Northern Coal Services

SSD-5145 Modification 4

Submissions Report

Company/s
Centennial Northern Coal Services Pty Limited
Date
12 August 2025
Version
Final
Prepared by:
Kirralee Jones - Approvals Officer Ron Bush - General Manager Development & Approvals

CENTENNIAL MANDALONG Pty Ltd
COORANBONG STOCKPILE EXTENSION
VEGETATION DISTURBANCE BOUNDARY
HISTORY - RESPONSE TO SUBMISSION
AUGUST 2025 - SHEET 5 OF 5

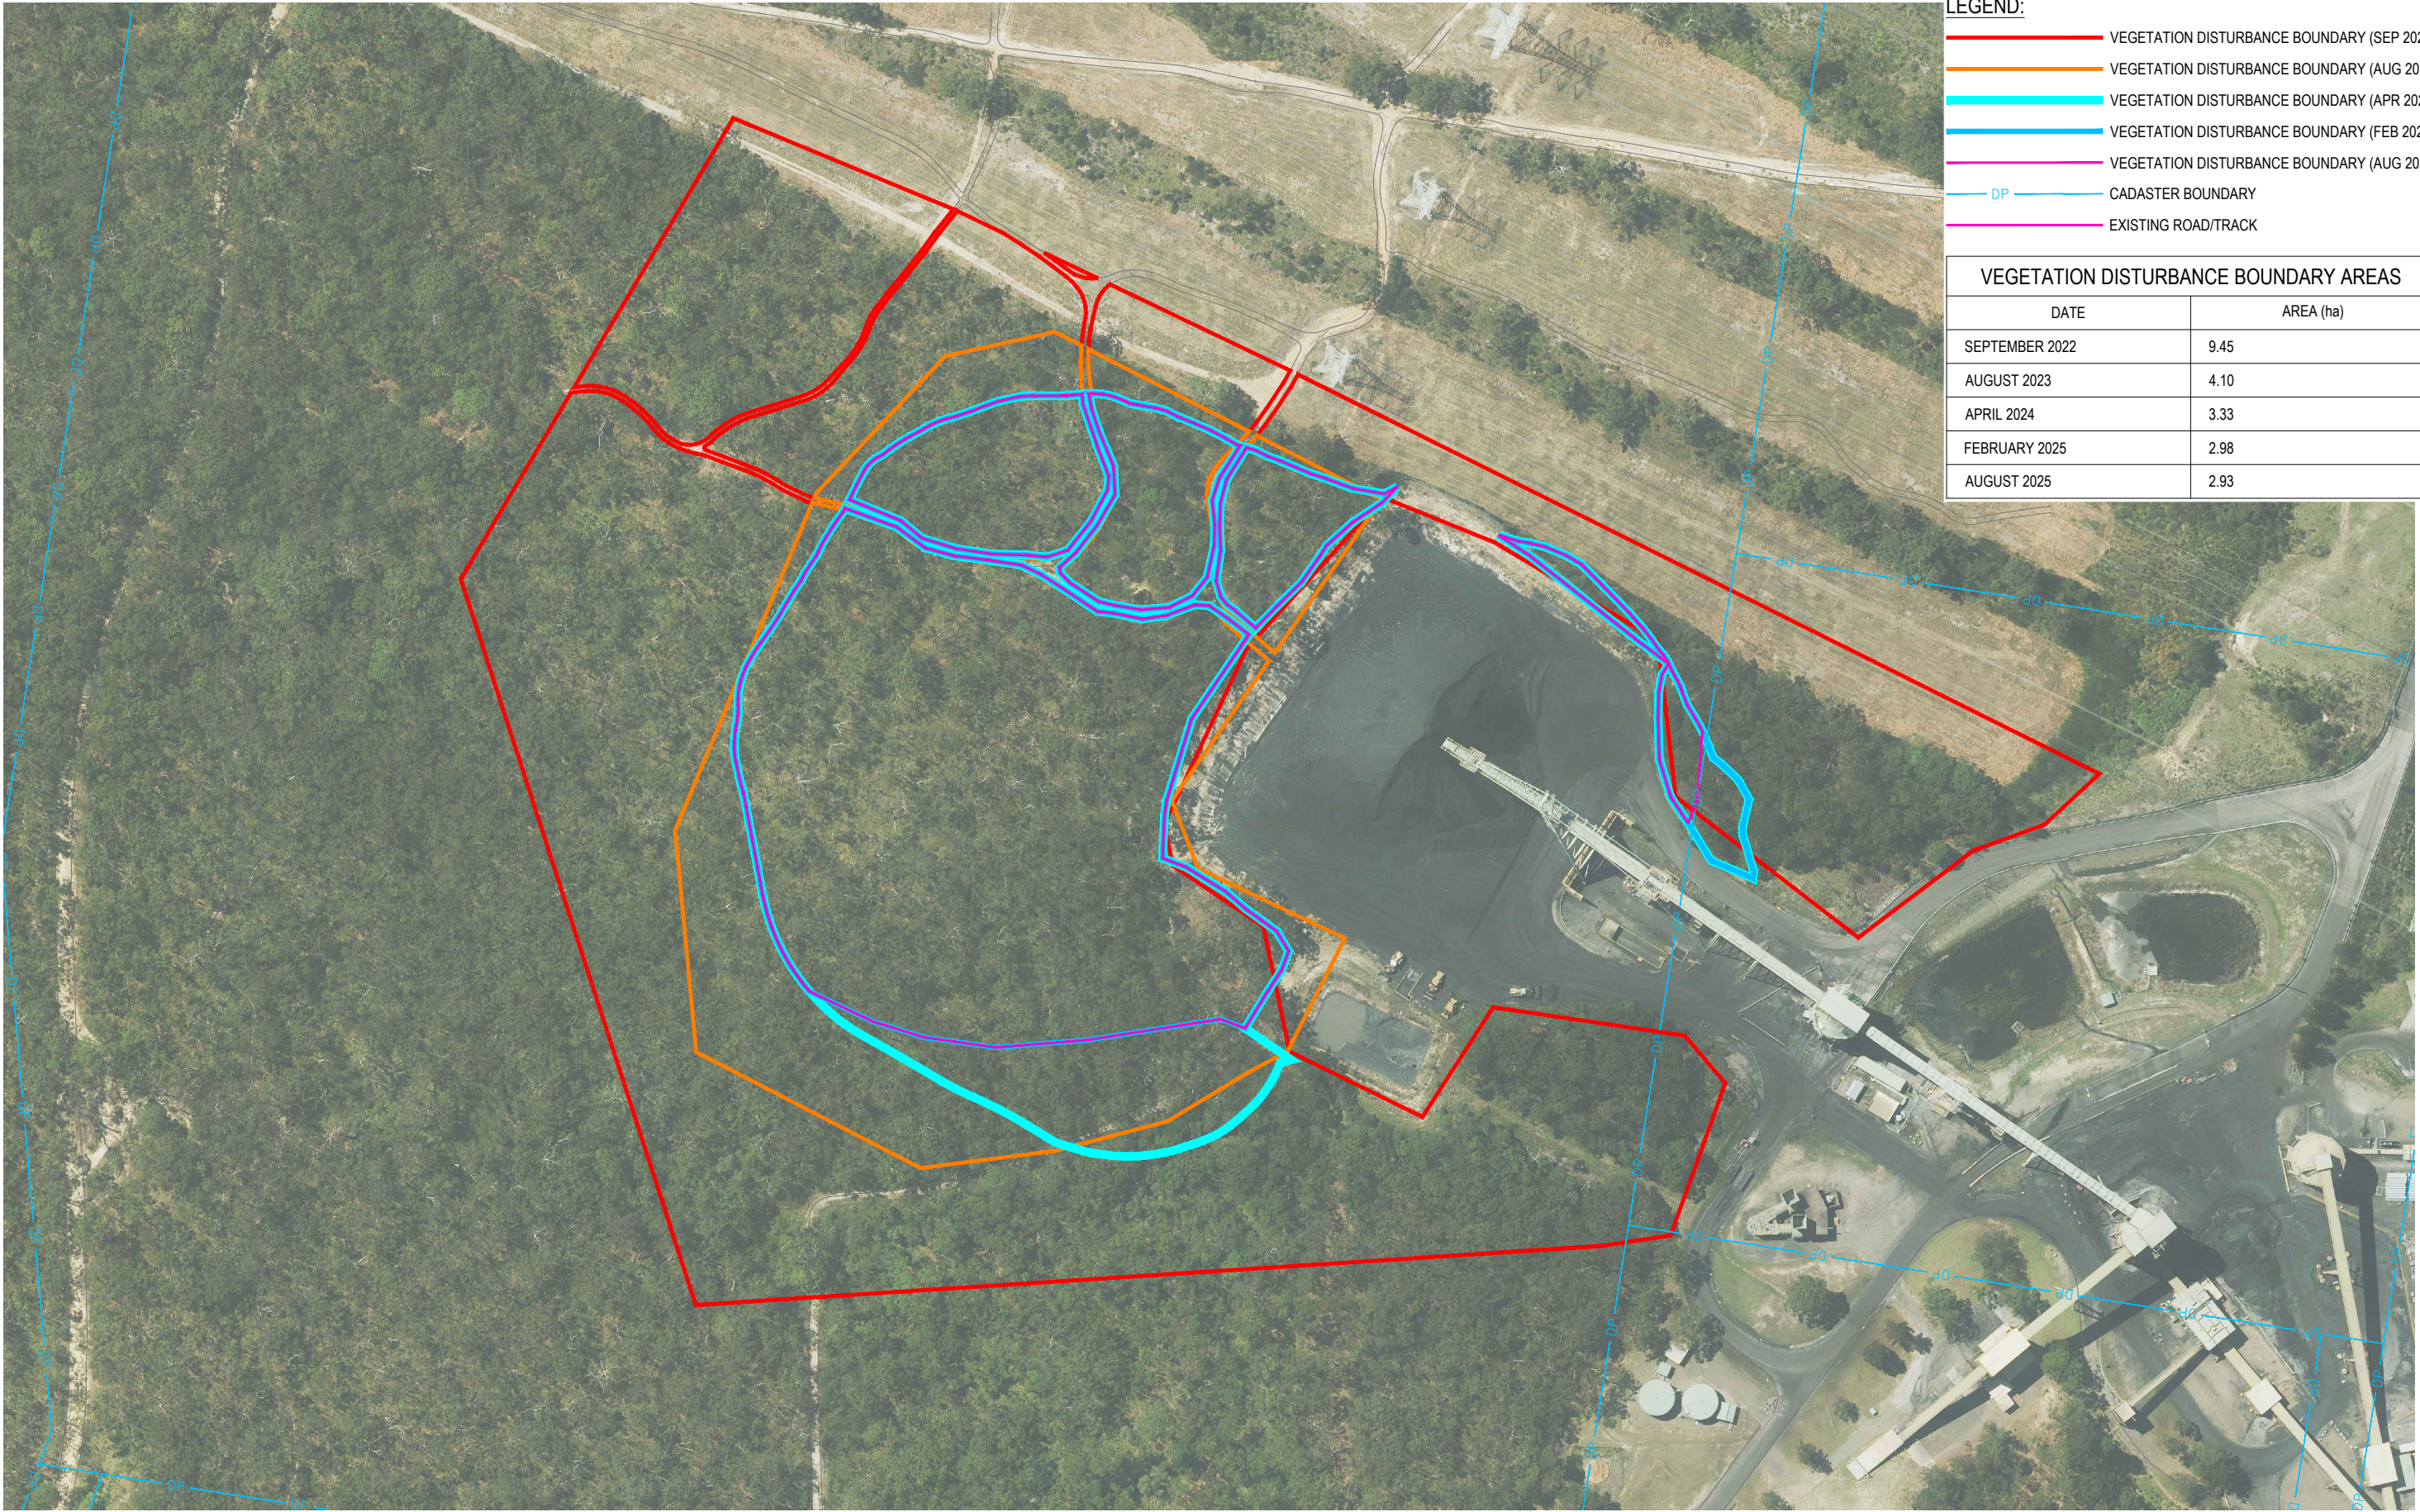
Further to the above, the parameters for a SBDAR have not been met. The modification disturbance area as depicted in the SBDAR appears to fall within two (2) lots, that being lot 7306/DP1164232 and lot 179/DP755218. Appendix C of the BAM 2020 stipulates the streamlined assessment module for small area developments must only be used in accordance with the area clearing thresholds specified.

Table 12 of the BAM 2020 outlines that when a minimum lot size associated with the proposal is less than 40ha but not less than 1ha, the applicable maximum clearing limit for application of the small area development module is 2ha, in which the current modification disturbance area currently exceeds.

We therefore consider that the Modification Application and Report does not meet the Secretary’s requirements for biodiversity as the SBDAR submitted is not considered compliant with the Biodiversity Assessment Method (BAM) 2020. As such, CPHR recommends a full BDAR should be submitted for the Modification Application and Report

In direct response to feedback from DCCEEW CPHR, the footprint of the proposed coal stockpile extension has been revised from 2.97 hectares to 2.93 hectares to address issues raised with the application of the Streamlined Biodiversity Development Assessment Report (**BDAR**). The key amendment to the stockpile design includes:

- Amendment to the stockpile design and associated drainage to exclude the stockpile footprint from extending onto Lot 179 DP755218, specifically to ensure the proposal remains within the biodiversity clearing thresholds outlined in the Biodiversity Assessment Method 2020 (**BAM 2020**) to enable use of the Streamlined BDAR.

The Streamlined BDAR has been completed to address the identified issues and reflect revision to the stockpile area layout. Specifically, the project footprint has been amended to exclude development on Lot 179 DP755218, ensuring that the disturbance area is entirely contained within Lot 7306 DP1164232, which has a minimum lot size of 40 hectares.

By limiting the extent of the disturbance to less than 3 hectares exclusively on Lot 7306 DP11642, the modification now complies with the eligibility criteria for the streamlined assessment pathway under the BAM 2020.
